City of Albuquerque Stormwater Construction Site Inspection Report

General Information					
ESC File No.	E19D025C2	Project Name:	Good 2 Go Store #333 Demolition		
NPDES Id. No.	N/A	Location:	7330 San Antonio Dr. NE		
6/28/2021	Owner			Contractor	
Operator	La Cueva Property, LLC		Emergency Environmental Services		
Contact name & title	Mike Petersen		Dan Kelley		
e-mail	mike.petersen@southforkmanagemen		dank@emergencyenv.com		
Contact Phone #			505-503-3884		
COA Inspector	Thomas Evans		Start/End Time:	1:00 PM-1:10 PM	
Construction Phase:	Demolition				
Type of Inspection:	Regular	Storm Event	Past Storm Event >0.25"	311/Complaint	Follow Up
Weather at time of inspection?	cloudy		Temperature: ~	78	
Estimated date of last storm 0.25" or greater	6/29/2021

GRADING & DRAINAGE PLAN

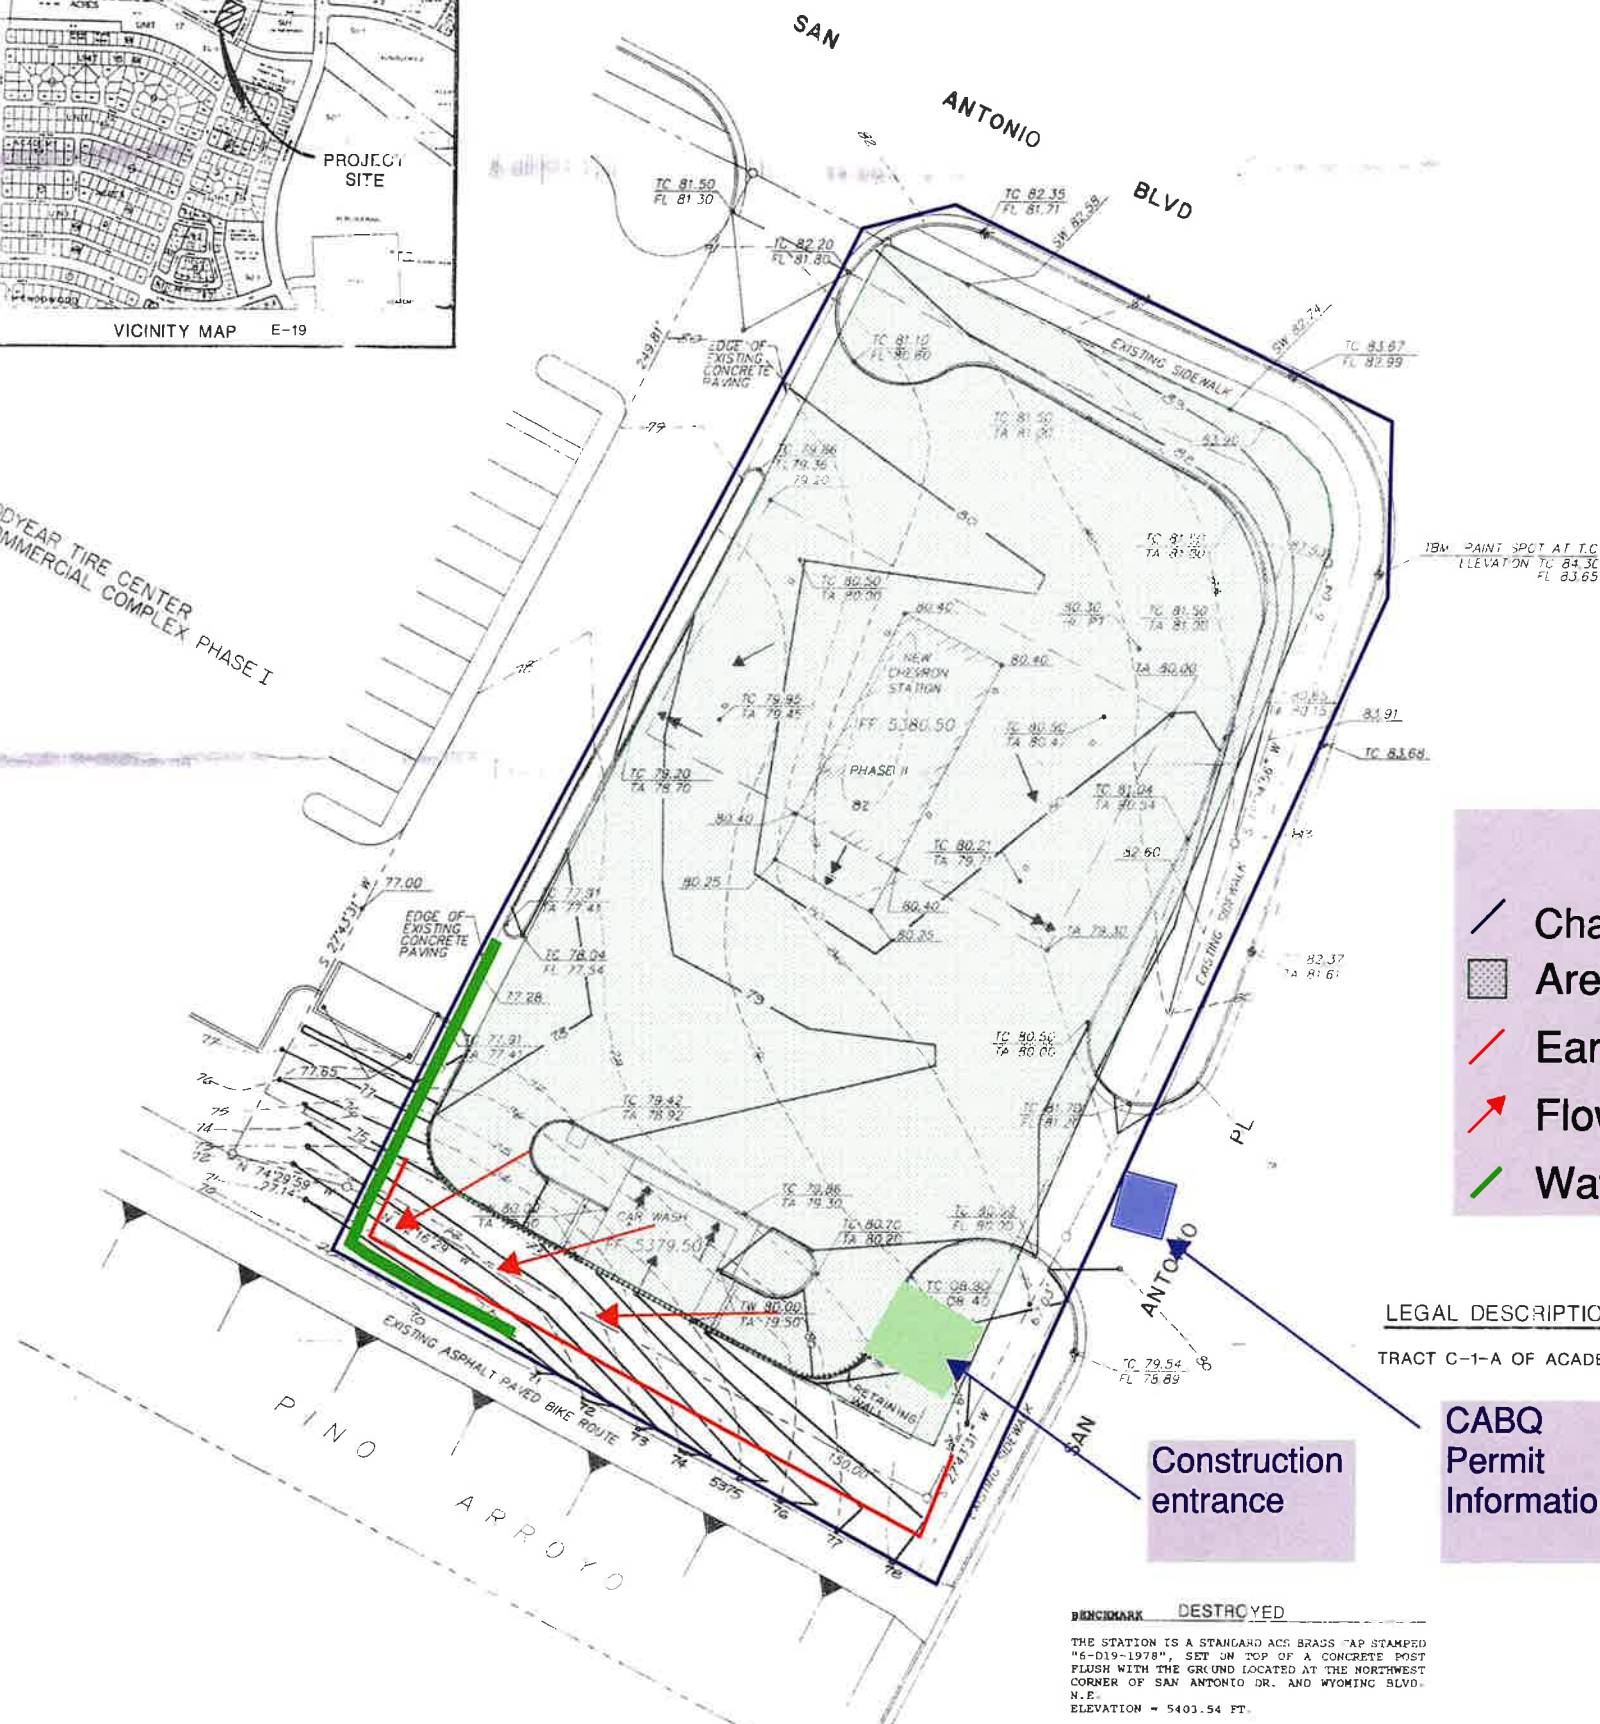
Item Number	Deficiency/ Corrective Action				
1	No posting of ESC Permit. Post ESC permit in a location clearly visible to the public.				
2	Wattles did not cover entire southern boundary. Crew placed wattles during inspection.				
3	Silt fence not towed at SW corner. Properly tow in silt fence.				
4					
5

Notes:	Building was approximately 95% demolished. Rolloff trucks were on site to haul debris.
	Spoke with crew member to install wattles and maintain the silt fence.
